I am placing this submission in objection to the amendments presented by Bowdens Silver for the changes to the extraction of water for the Proposed Bowdens Silver Mine at Lue.

Doc A. EIS – Predicted Drawdown 15.5yrs.

Doc B. Amendment 2 – Predicted Drawdown 15.5yrs.

Doc C. Wyuna – Predicted Drawdown.

# PREDICTED DRAWDOWN

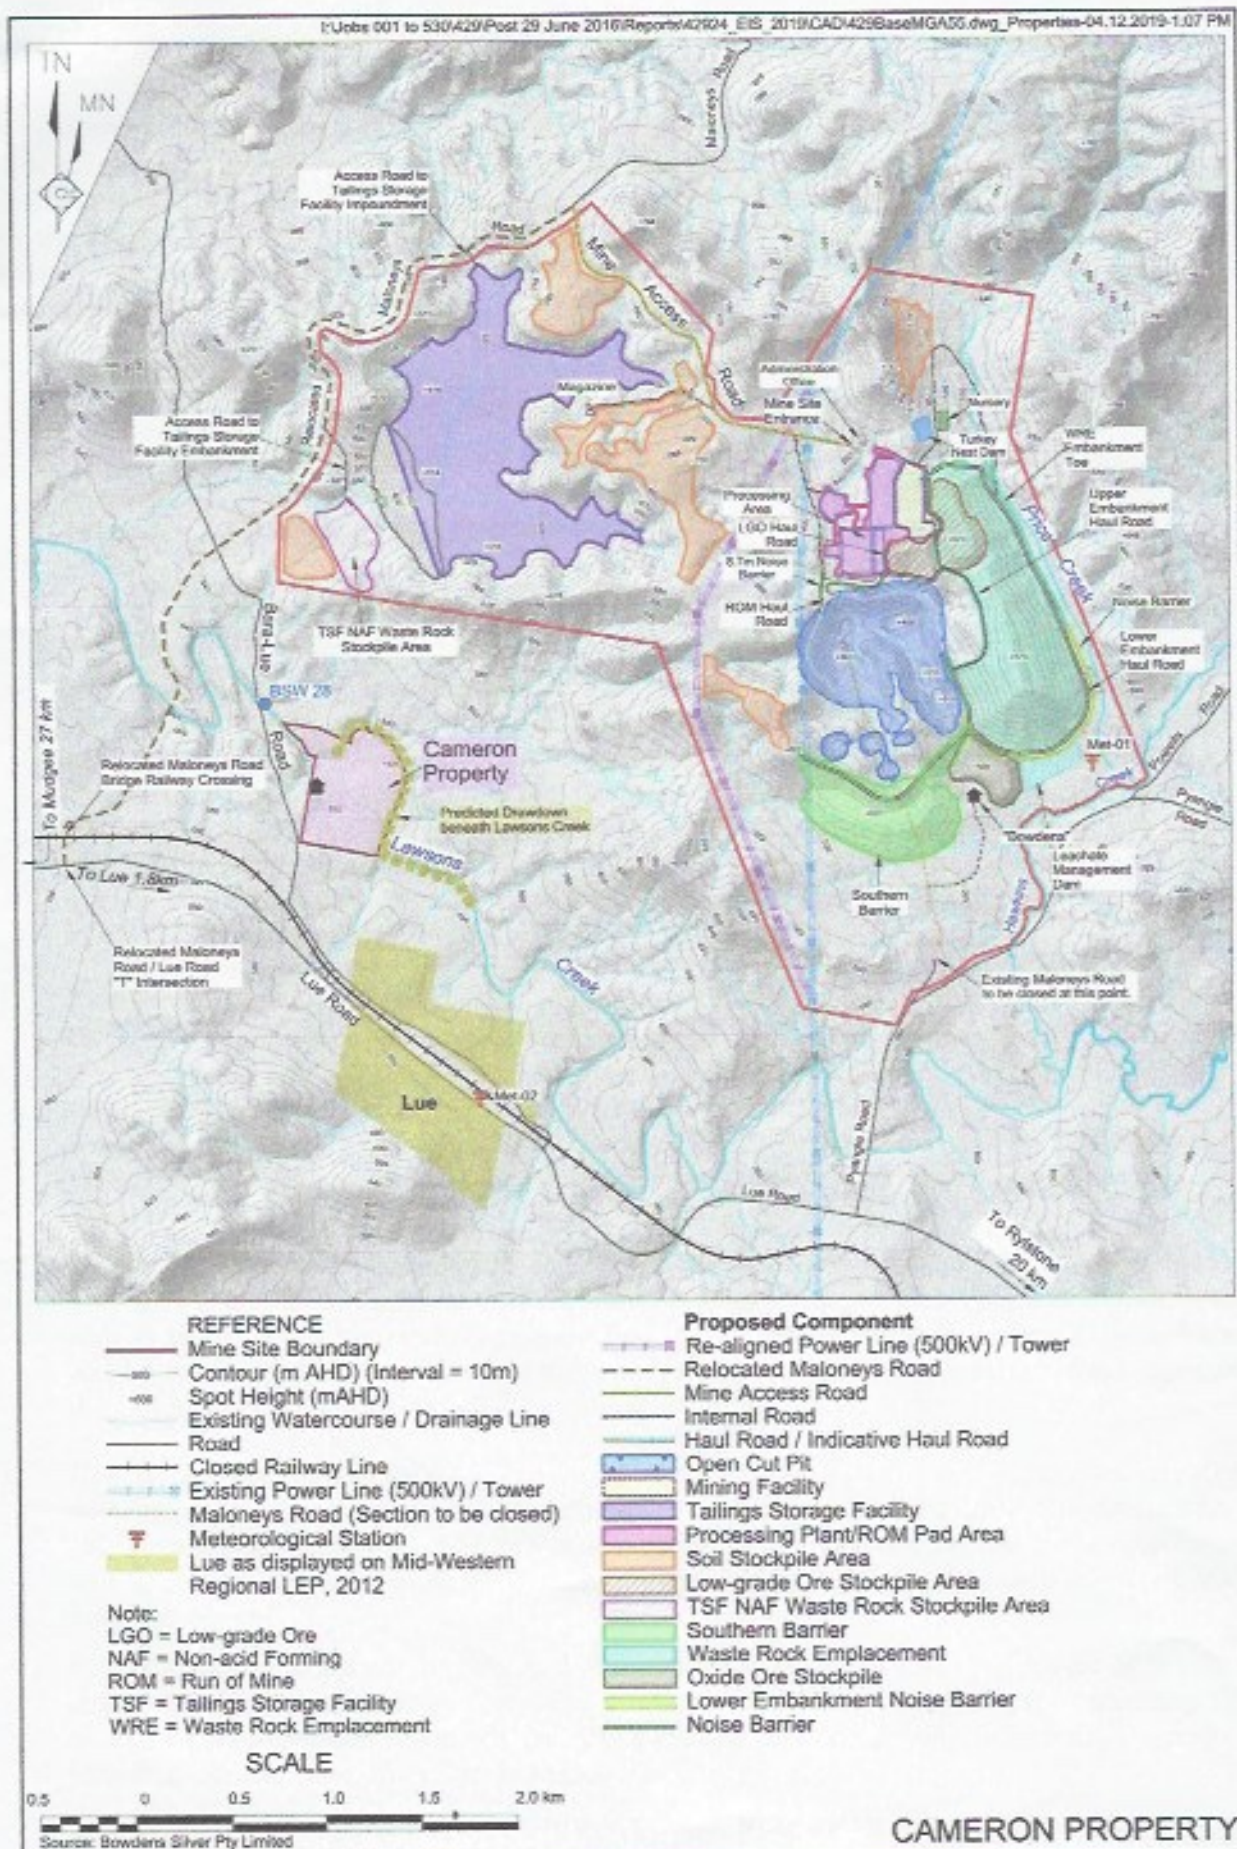
This map was produced in 2019 which was well before the external water pipeline was removed from the project. The area highlighted covers most of the creek where it runs through our property and right passed our pump site.

This map clearly shows then that there was problems with the modelling back then and with more water taken from the surrounding lands now the problem will be even worse.
